**Planning Applications, Ribble Valley District
D3-10-0324 Freemasons Arms, 8 Vicarage Fold, Wiswell**

I refer to your letter of 5 May 2010 concerning the above application.

102 COVERS

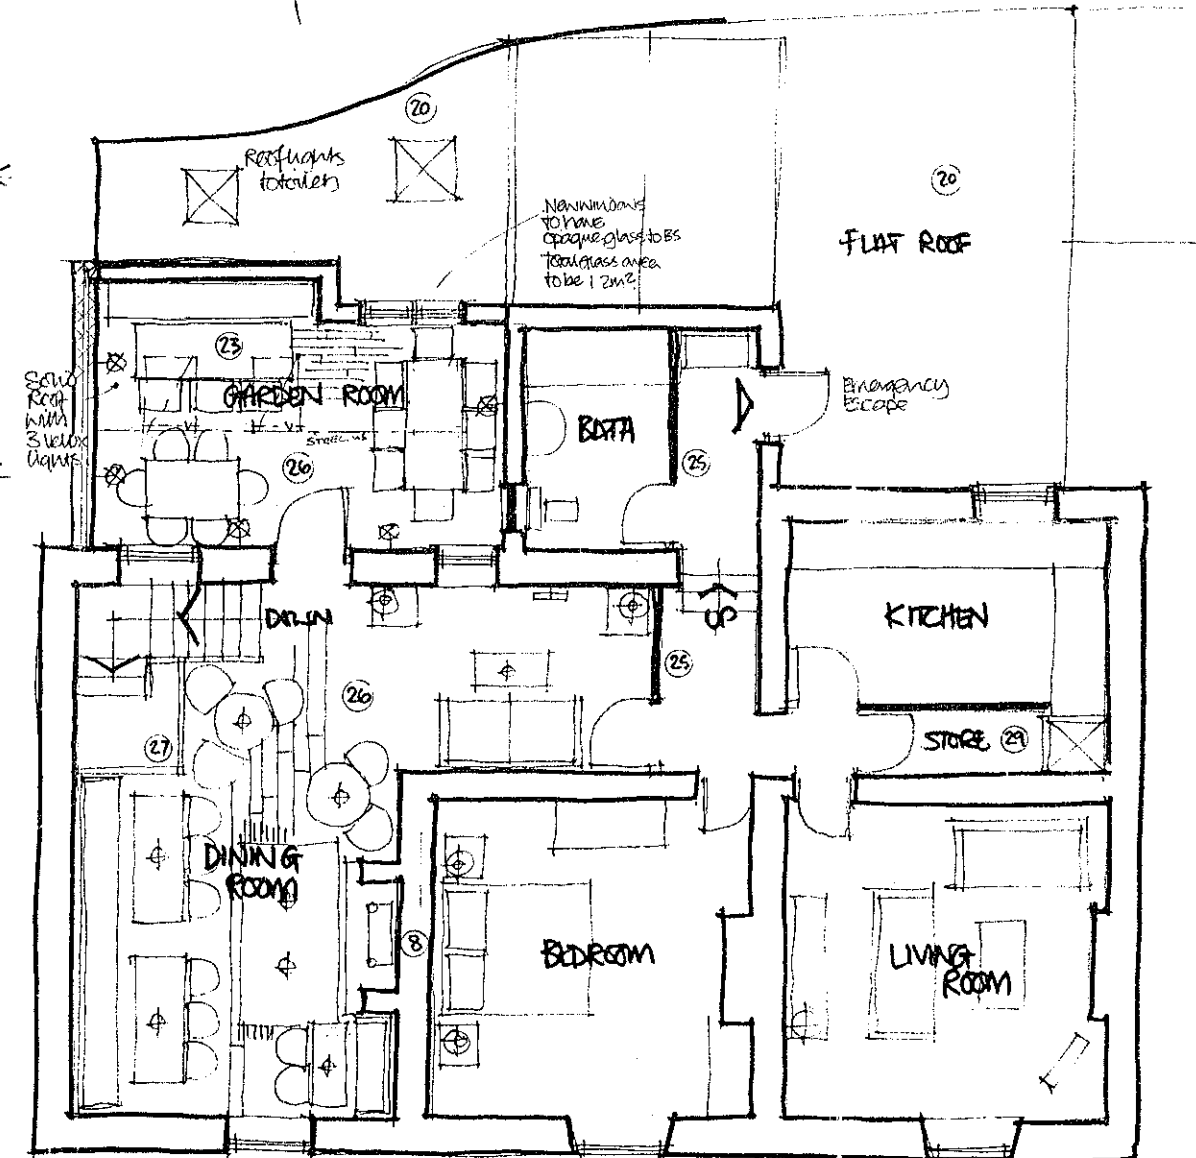
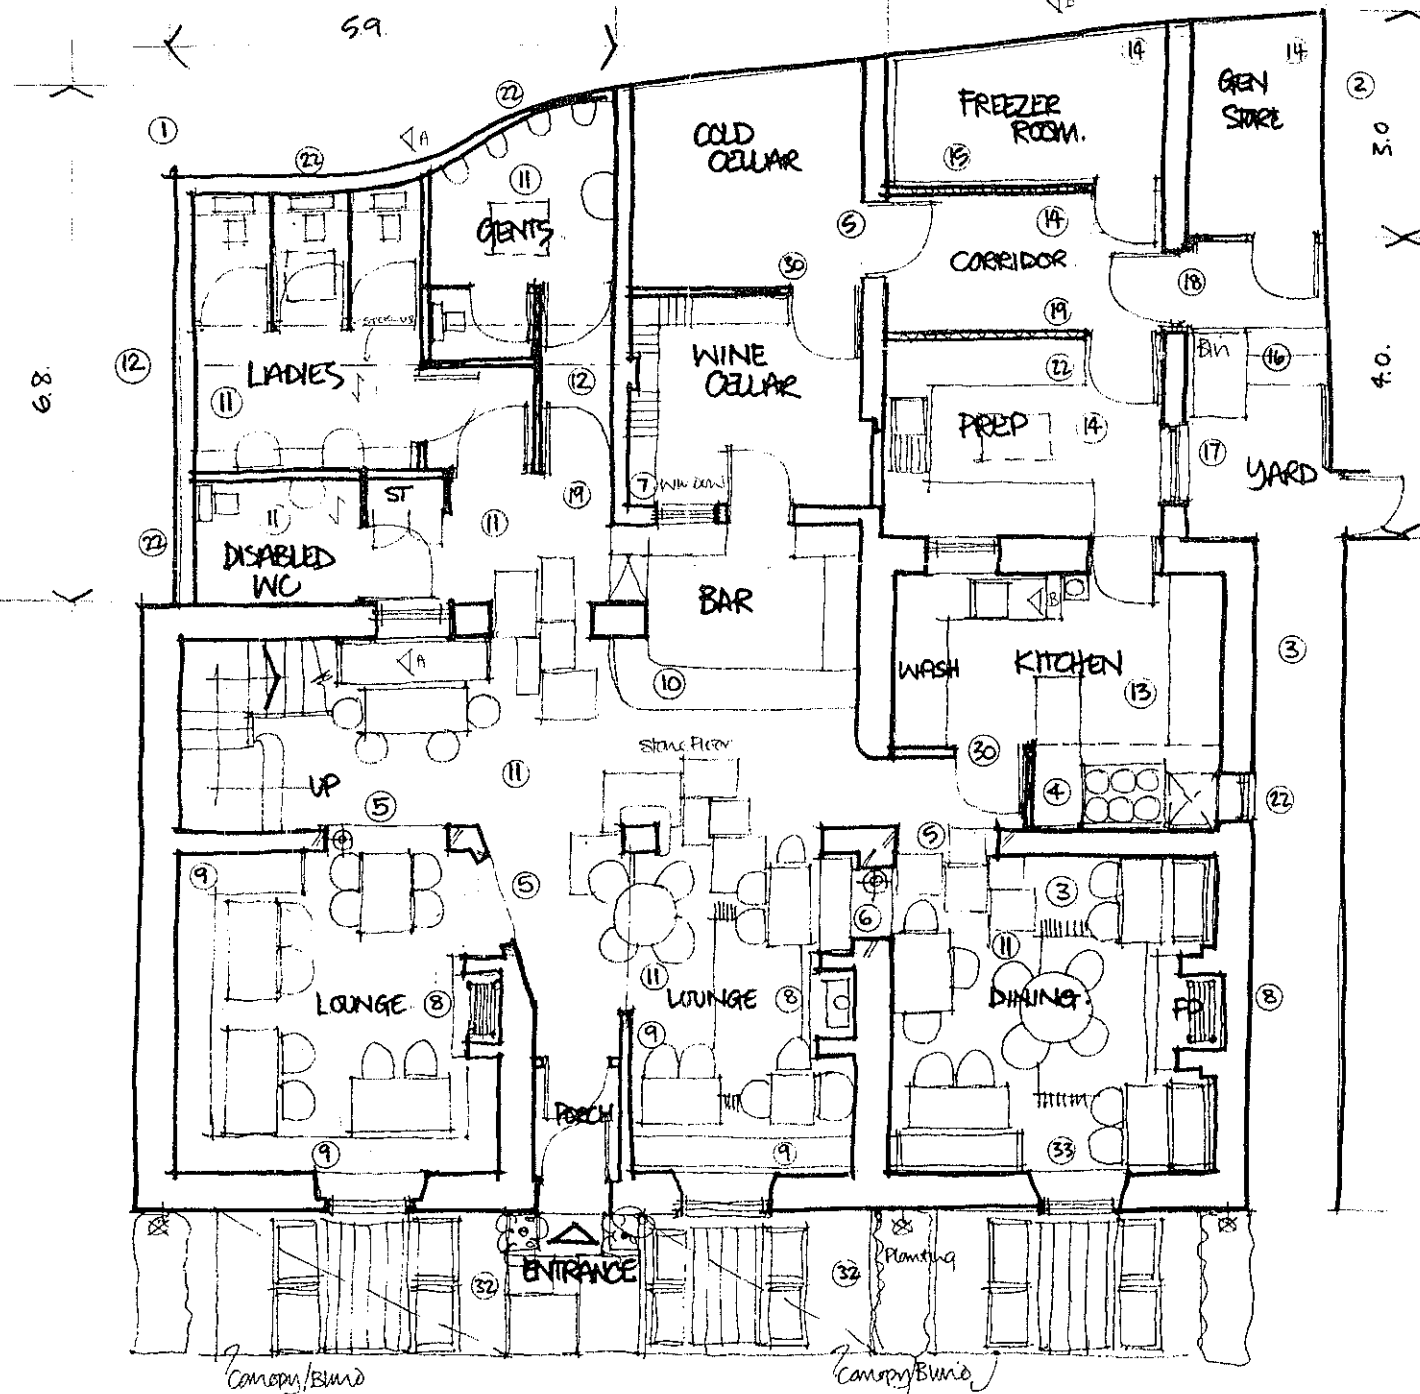
However, the proposed changes indicate a reduction in the number of covers being provided, falling from 102 to 82. The plans provided show this being achieved through a revision of the table layout to reduce the density of seating.

Drawing Title
SEATING PLAN AS
CURRENTLY IN USE
APRIL 2010

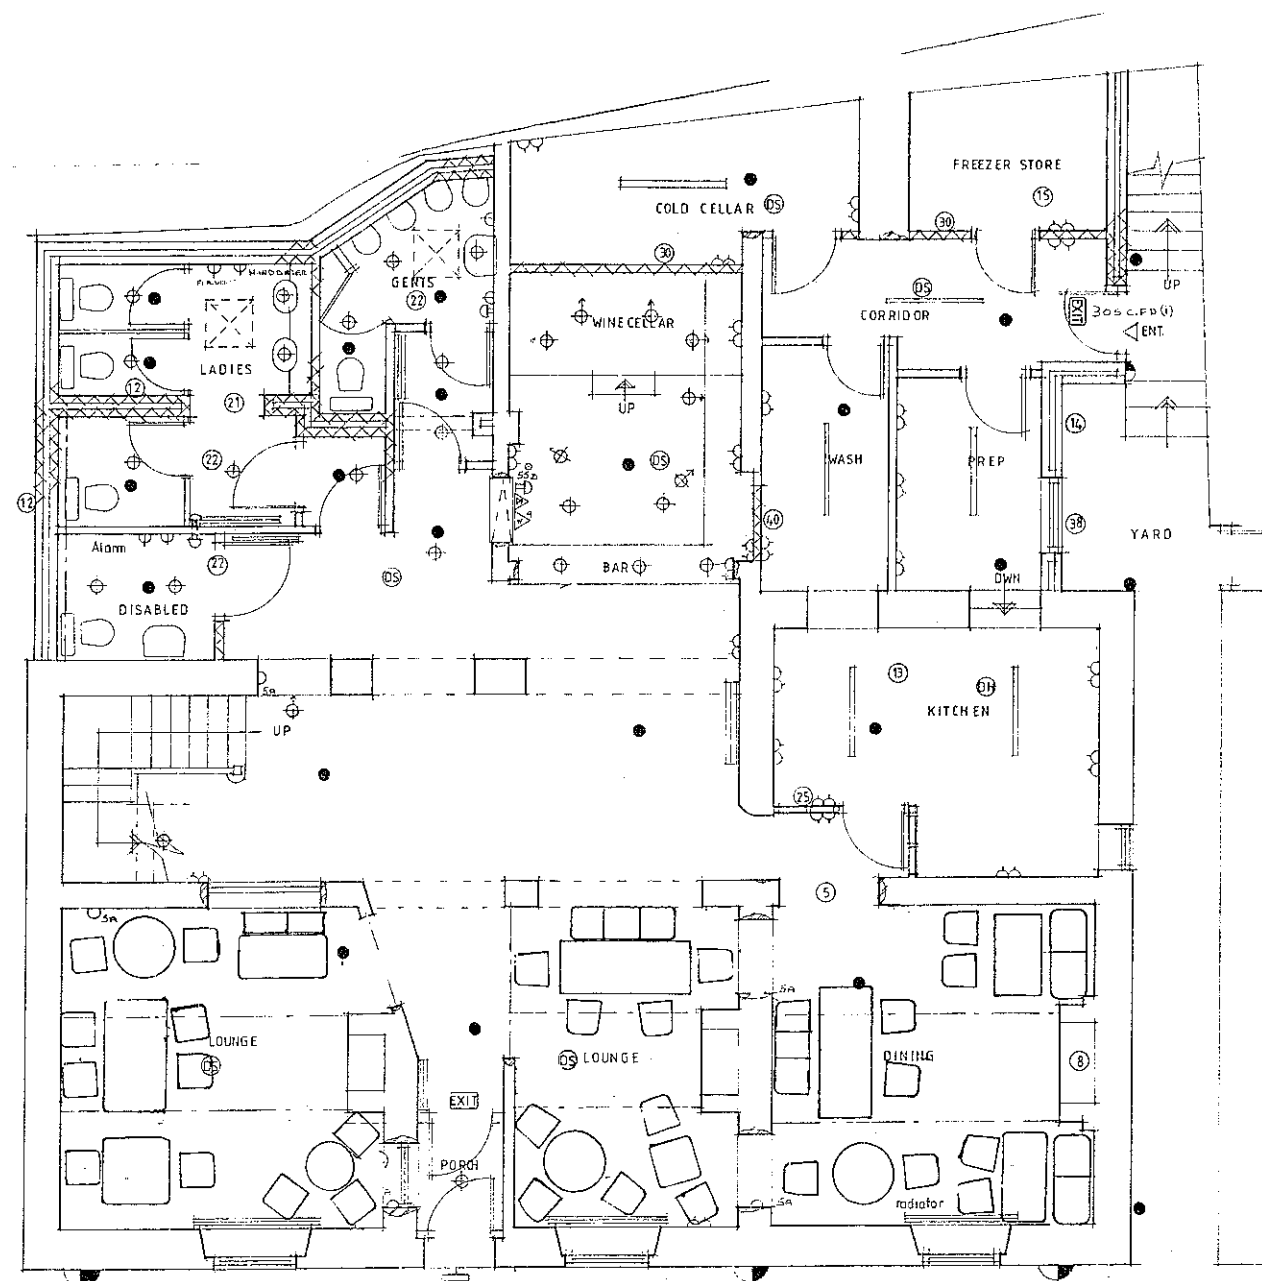
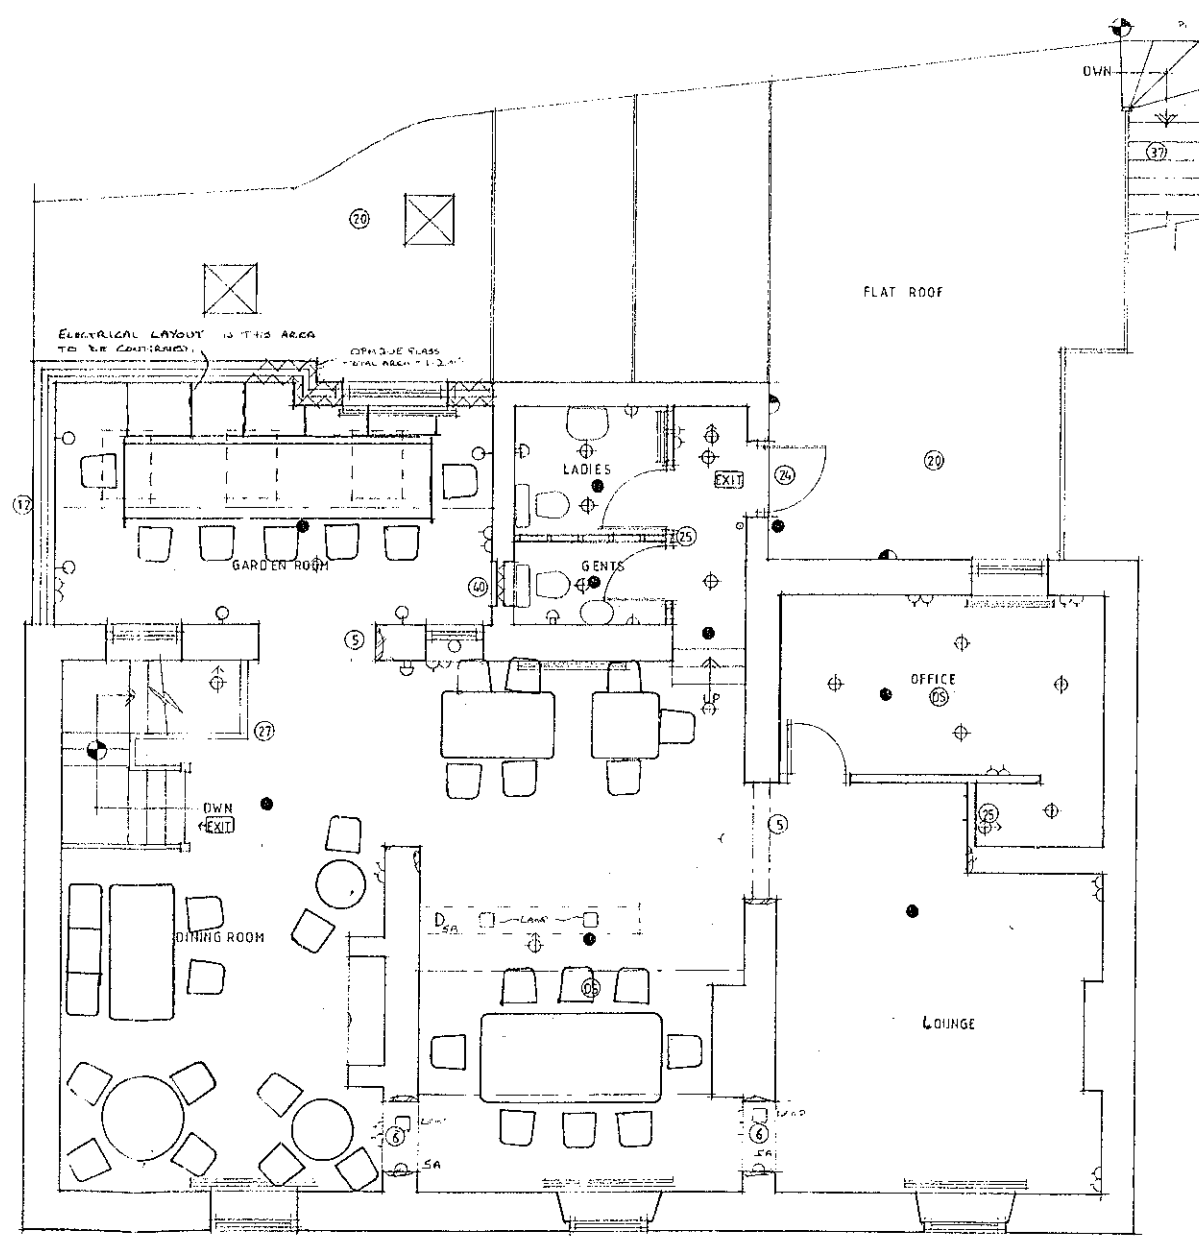
I am satisfied that a reduction of this magnitude in the number of covers being provided will have a positive impact on the demand for on street parking within the village.
